# CITY OF ALBUQUERQUE

August 30, 2016

**Re: McMahon Marketplace-5708 McMahon Blvd NW  
Erosion and Sediment Control Plan  
Engineer's Stamp Date 8-23-16 (D18E054B)**

#### Erosion Sediment Control Plan

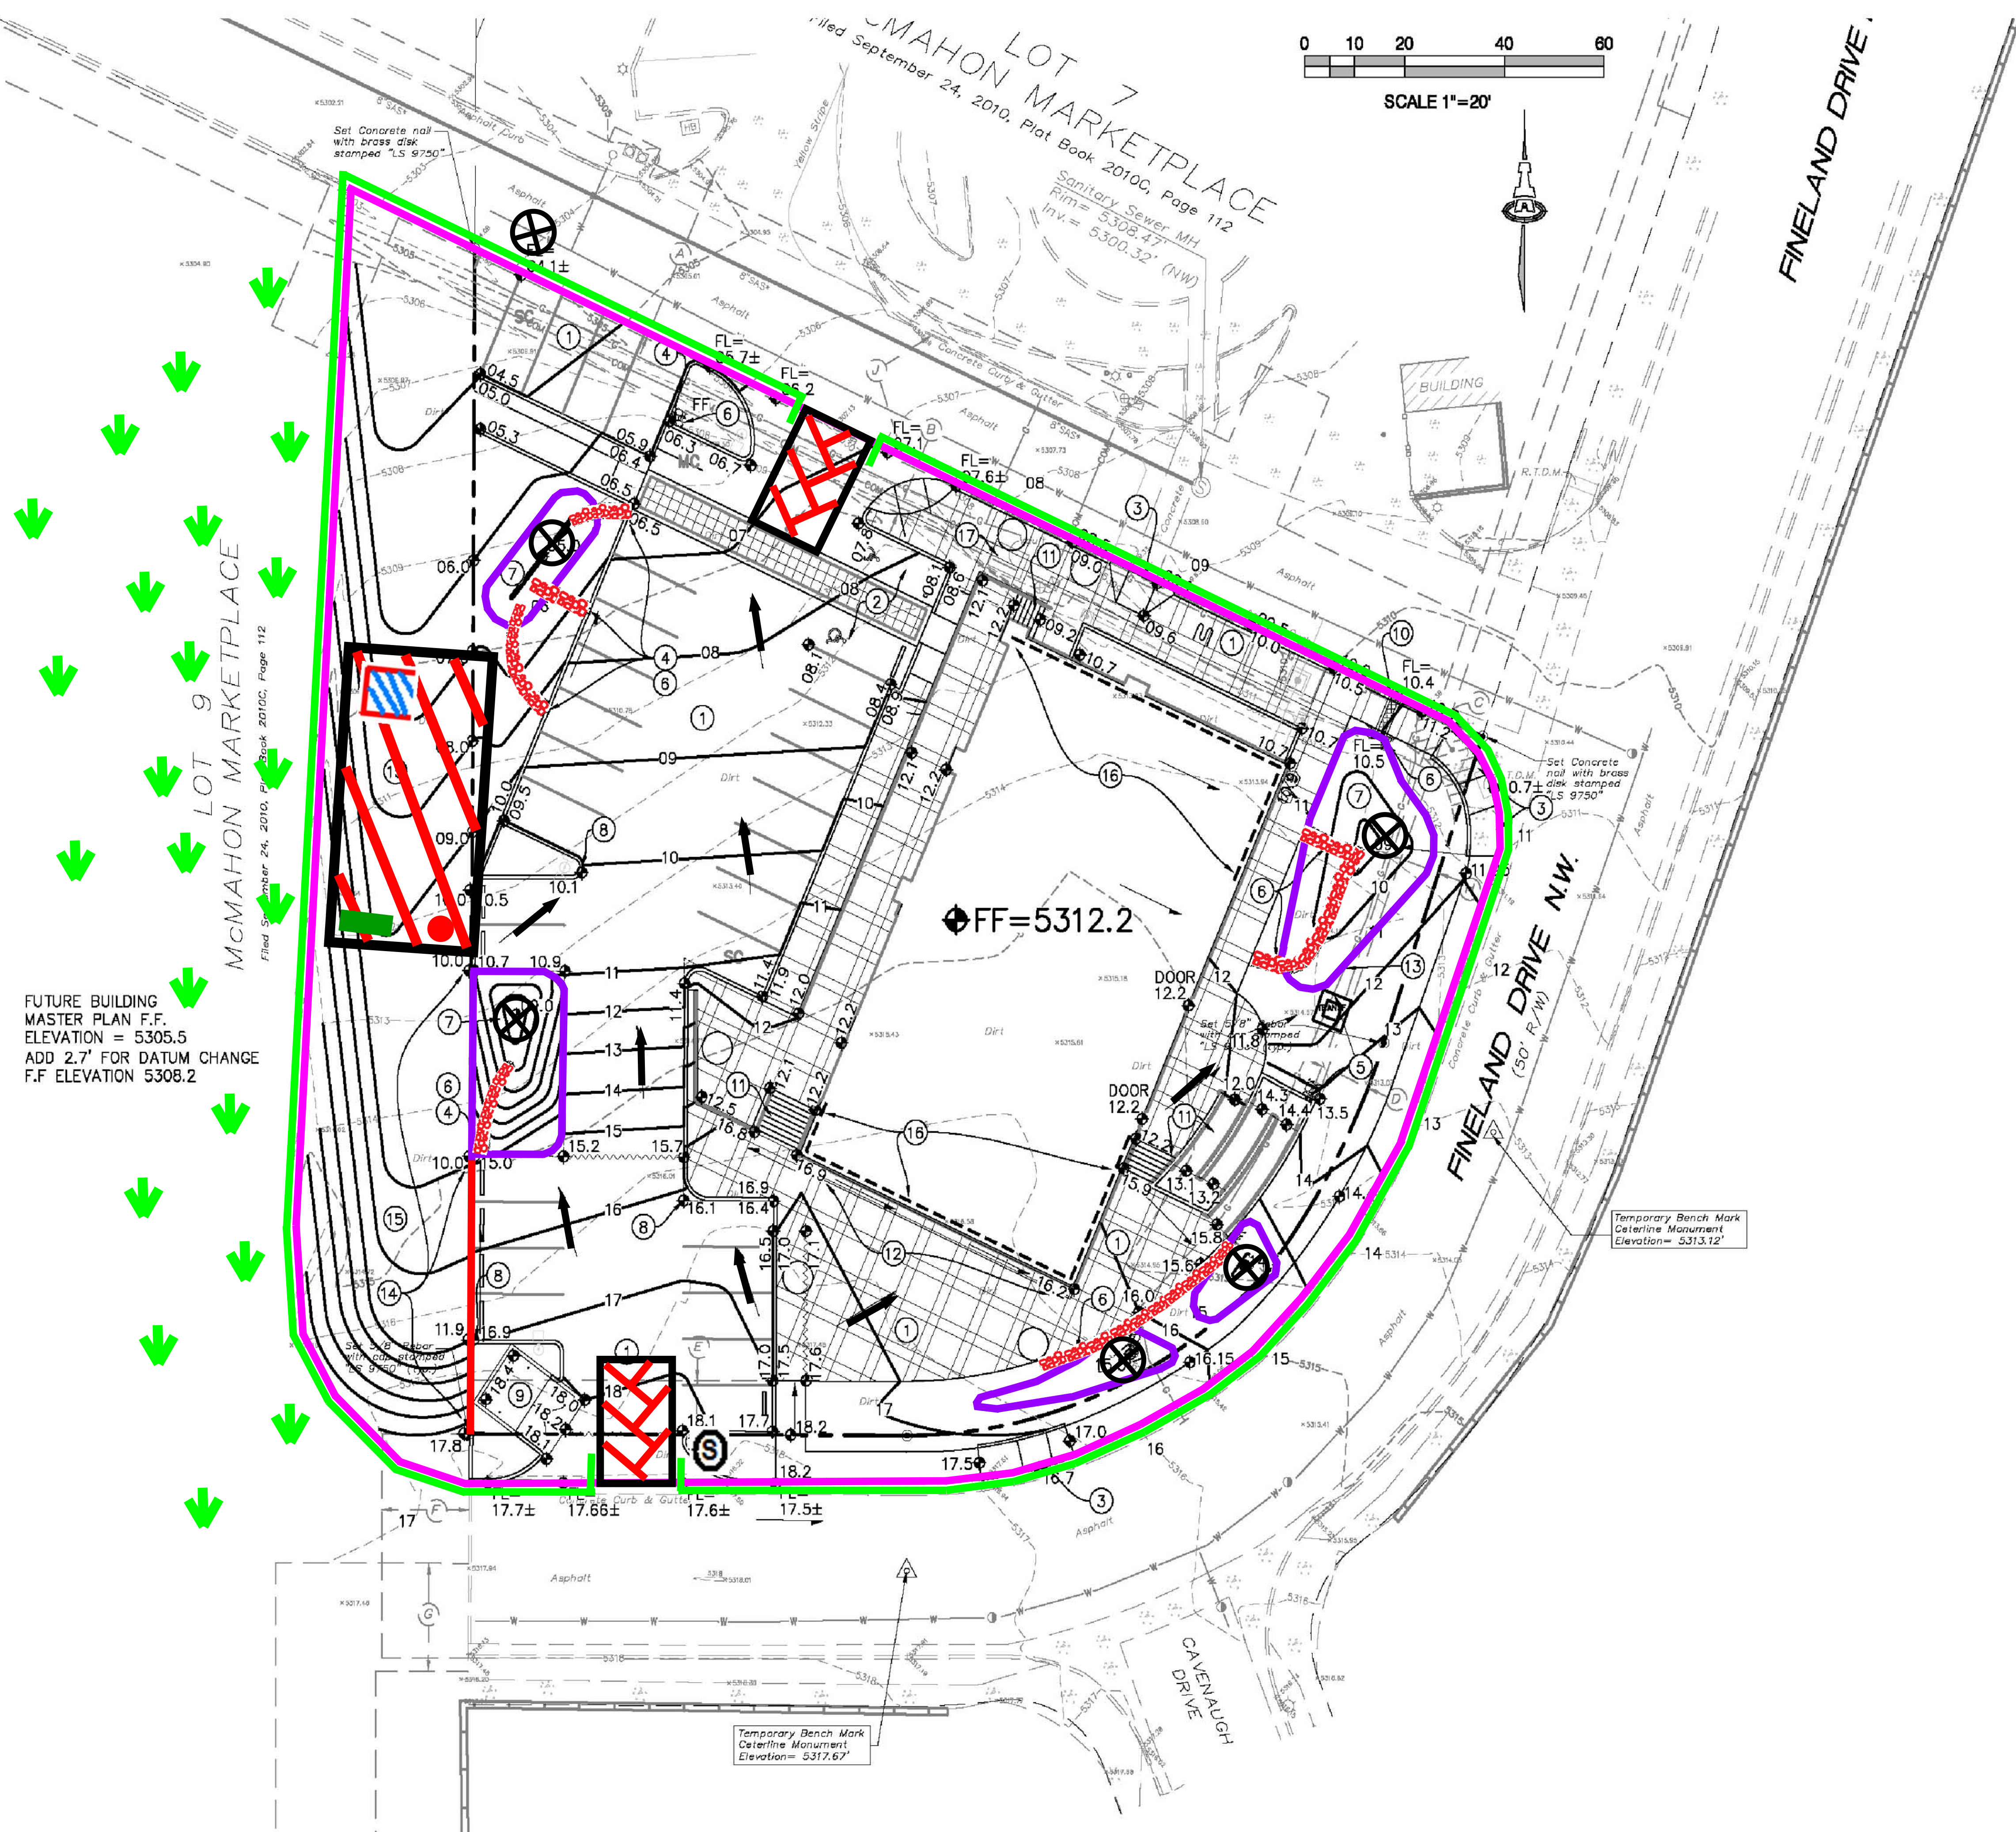
1. Include a berm at the northwest corner that ties at the 06 contour on the west and north sides (berm around inside of NW corner).
2. It may be beneficial to extend the silt fence south on the east side of the north construction entrance about 20 feet to prevent sediment from leaving out the construction entrance.
